**RE: RESPONSE TO ADDITIONAL QUERIES SSD-76555711 – 3-5 HELP STREET, CHATSWOOD**

This letter has been prepared by Mecone on behalf of Loftex Chatswood Pty Ltd (the applicant) in relation to the State Significant Development Application (SSDA) SSD-76555711 for 3-5 Help Street, Chatswood (the site).

Drawing
 View from the Sun
 June 22 - 1200

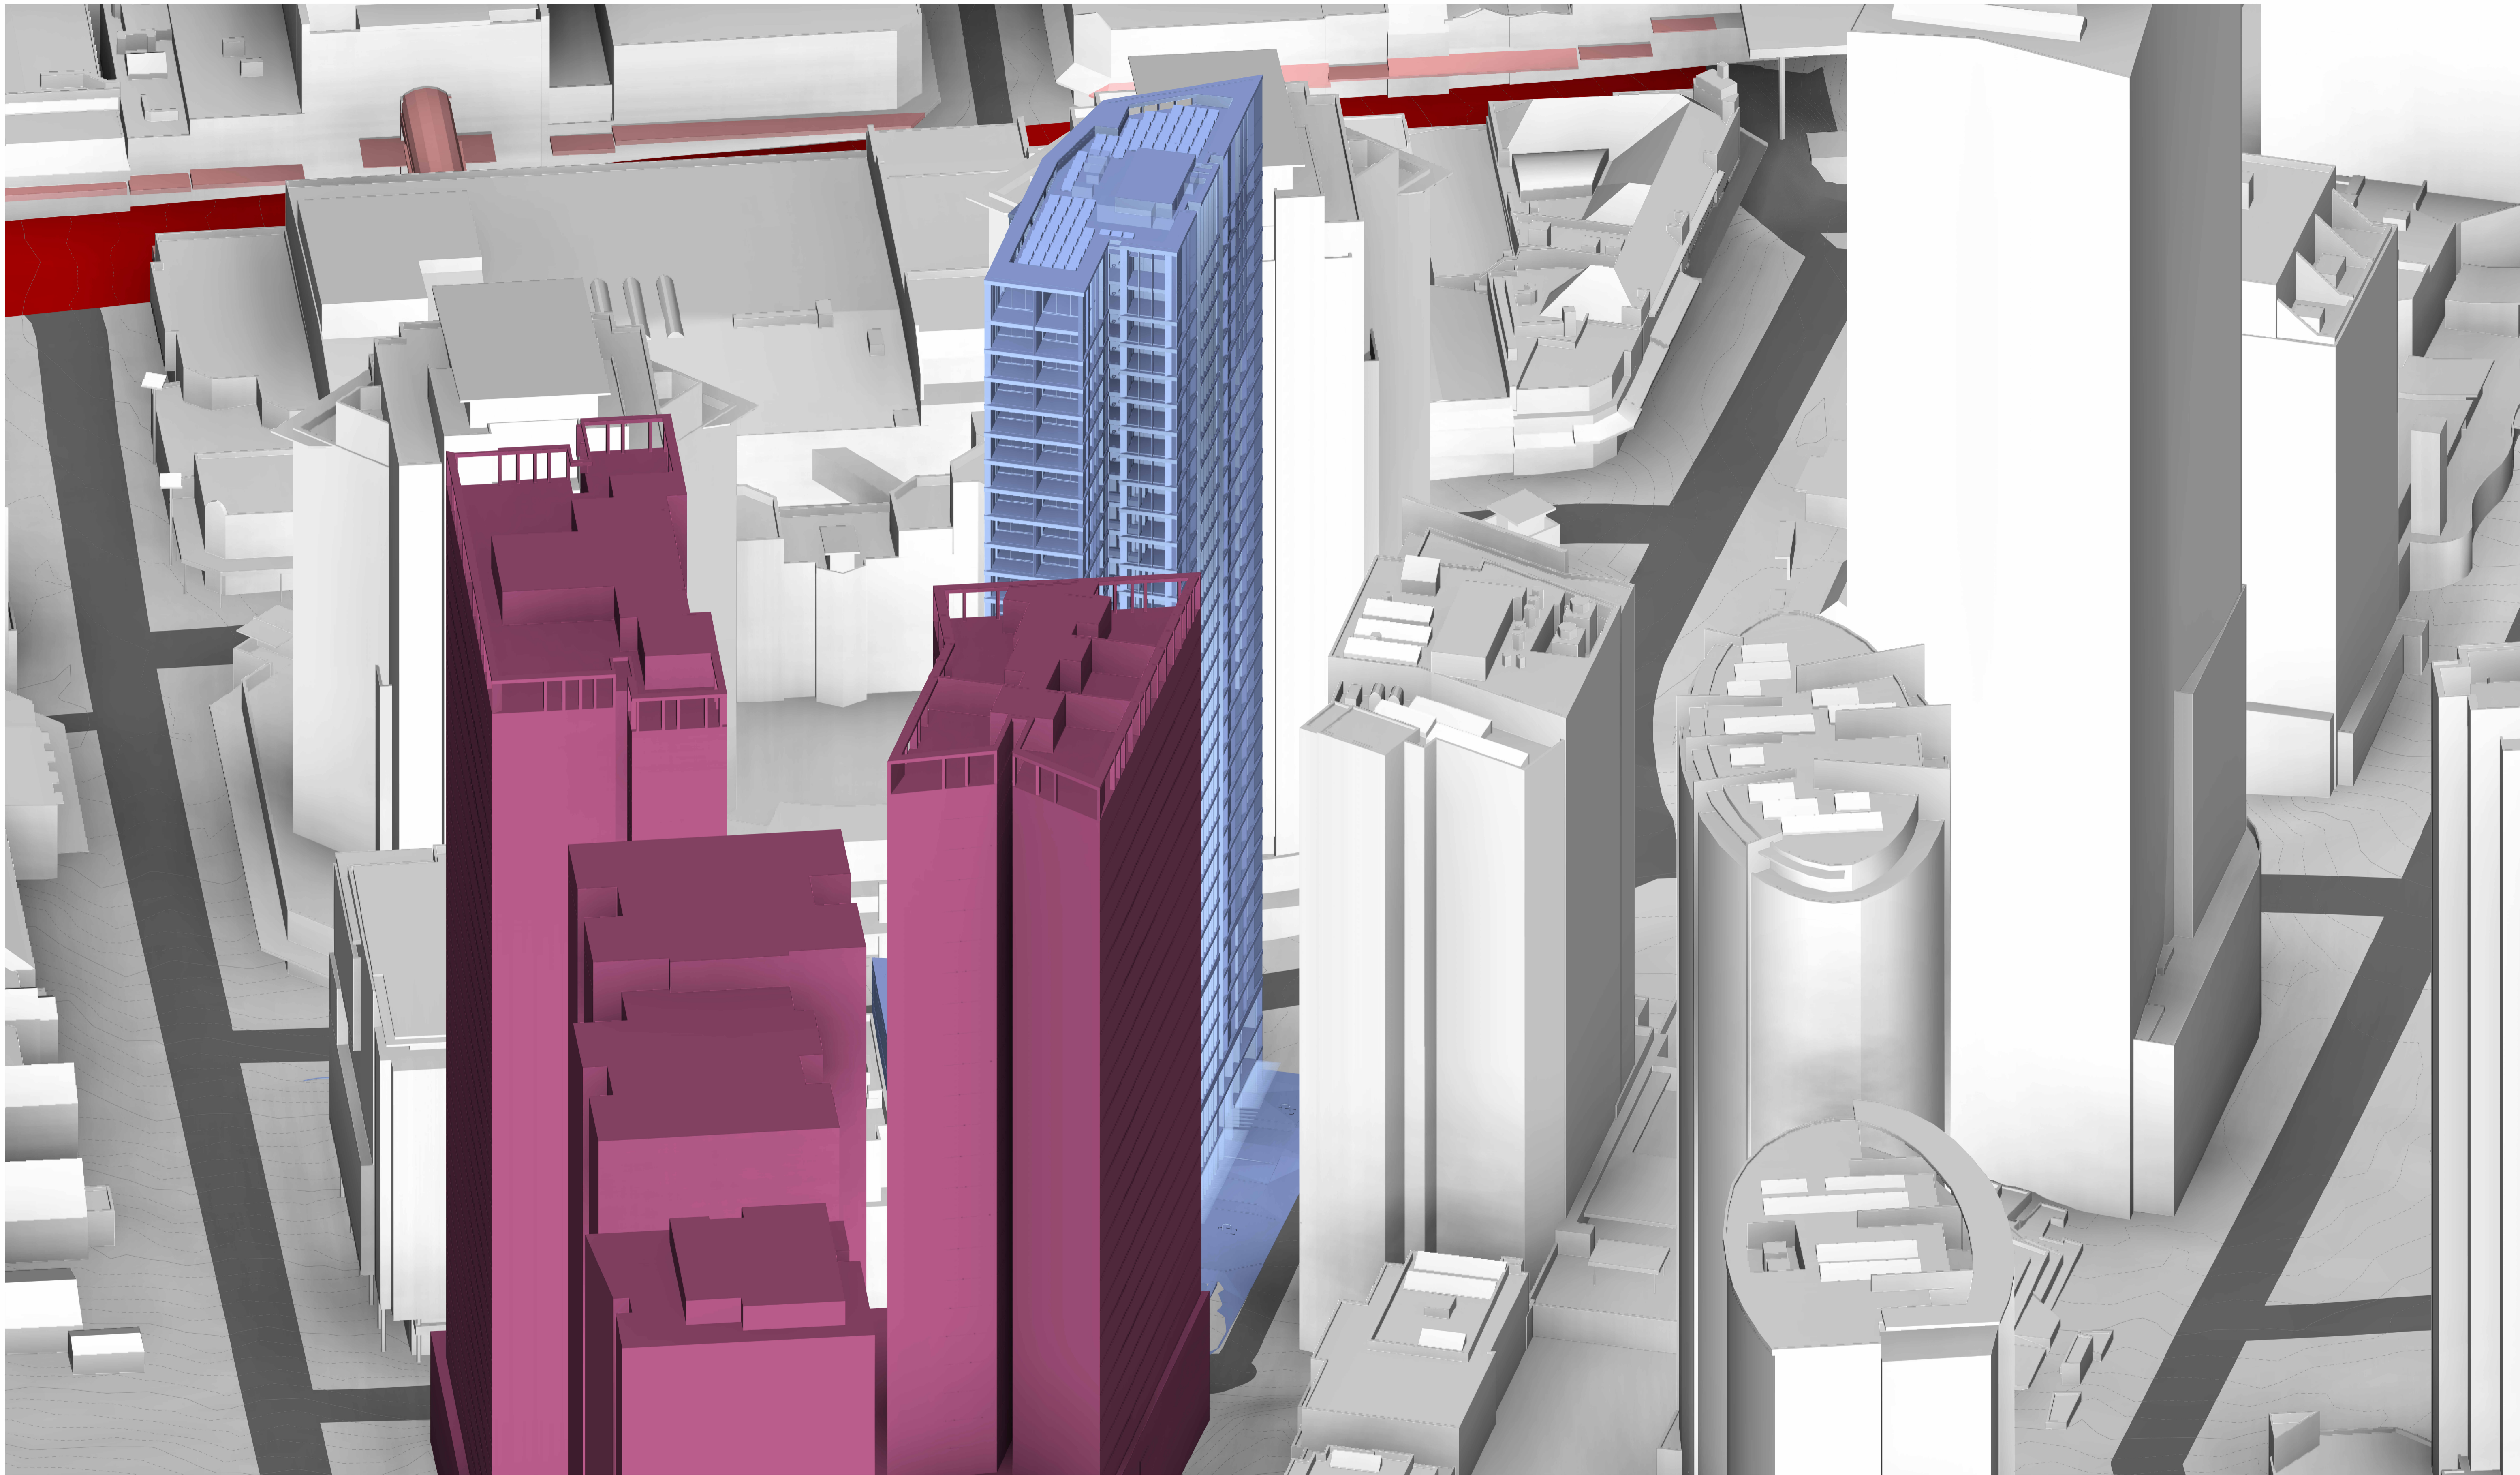
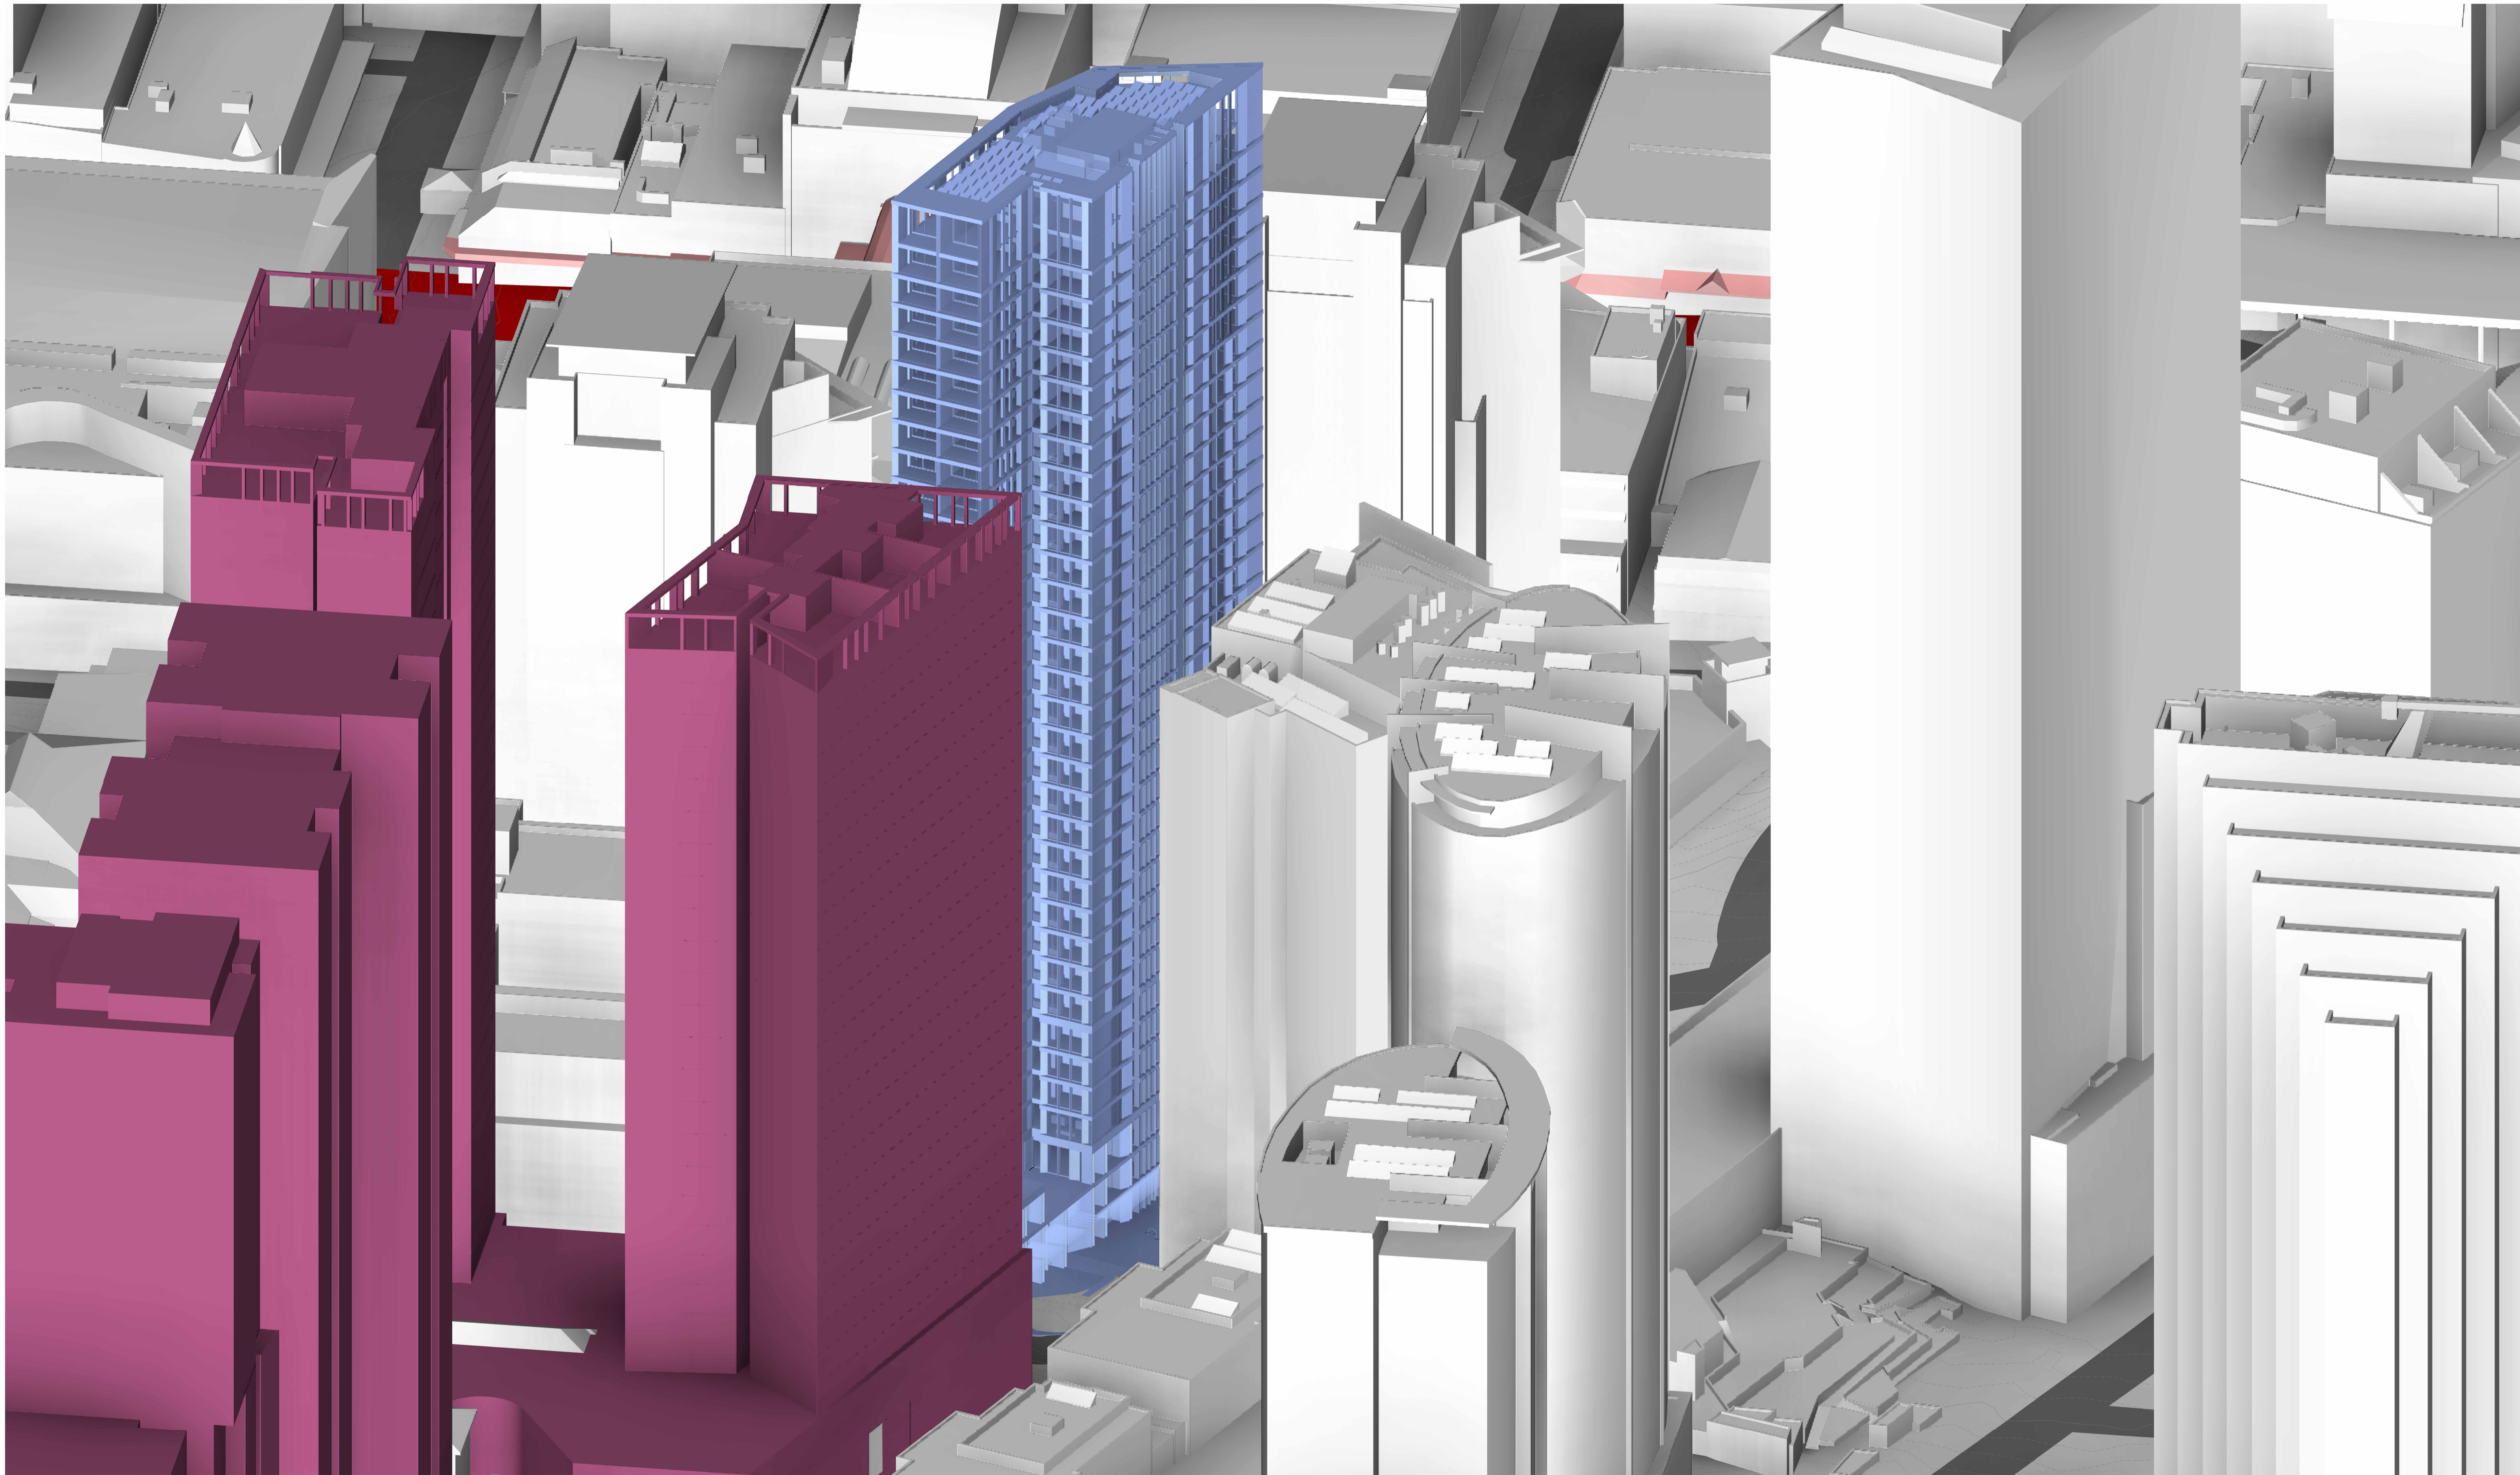
Comment/Query	Response
<b>Solar Access</b>	
<p><b>The following was requested via email from DPHI on 13 October 2025:</b></p> <p><i>The application would benefit from additional solar access data detailing 5–10 minute intervals of sunlight exposure for apartments receiving less than two hours of direct sunlight. This information would strengthen my assessment report by allowing a more thorough discussion of the limitations posed by the proposed northern buildings and demonstrating that the design has maximised solar access to the greatest extent possible.</i></p> <p><b>The following was requested via email from DPHI on 14 October 2025:</b></p> <p><i>Following on from my additional information request yesterday, could you please also supply solar access data from 8am-9am and 3pm-4pm to help justify the site not meeting the ADG sunlight requirements?</i></p>	<p>As requested, the updated View from the Sun Diagrams have been provided at <b>Attachment 1</b> and <b>Attachment 2</b>, showing the solar access to the building façade in 15-minute increments from 8am to 4pm.</p> <p>A detailed statement addressing solar impact has been provided by EMBECE at <b>Attachment 3</b>. In summary, if the proposed SSDA to the north of the site is approved in its current form, with the consideration of extended solar access hours to include 8am-9am and 3pm-4pm, then at least 119 of 166 apartments (74%) will receive 2 hours of sunlight to either the habitable rooms or private open space between the hours of 8am to 4pm on June 21,.</p> <p>Noting that 74% of apartments will still have access to sunlight in mid-winter, despite the proposed SSDA to the north, is evidence that the proposal can satisfy the objectives of Part 4A-1 of the ADG.</p> <p>A detailed summary of how the design achieves compliance with the objectives of Part 4A-1 of the ADG is provided in <b>Attachment 3</b>.</p>
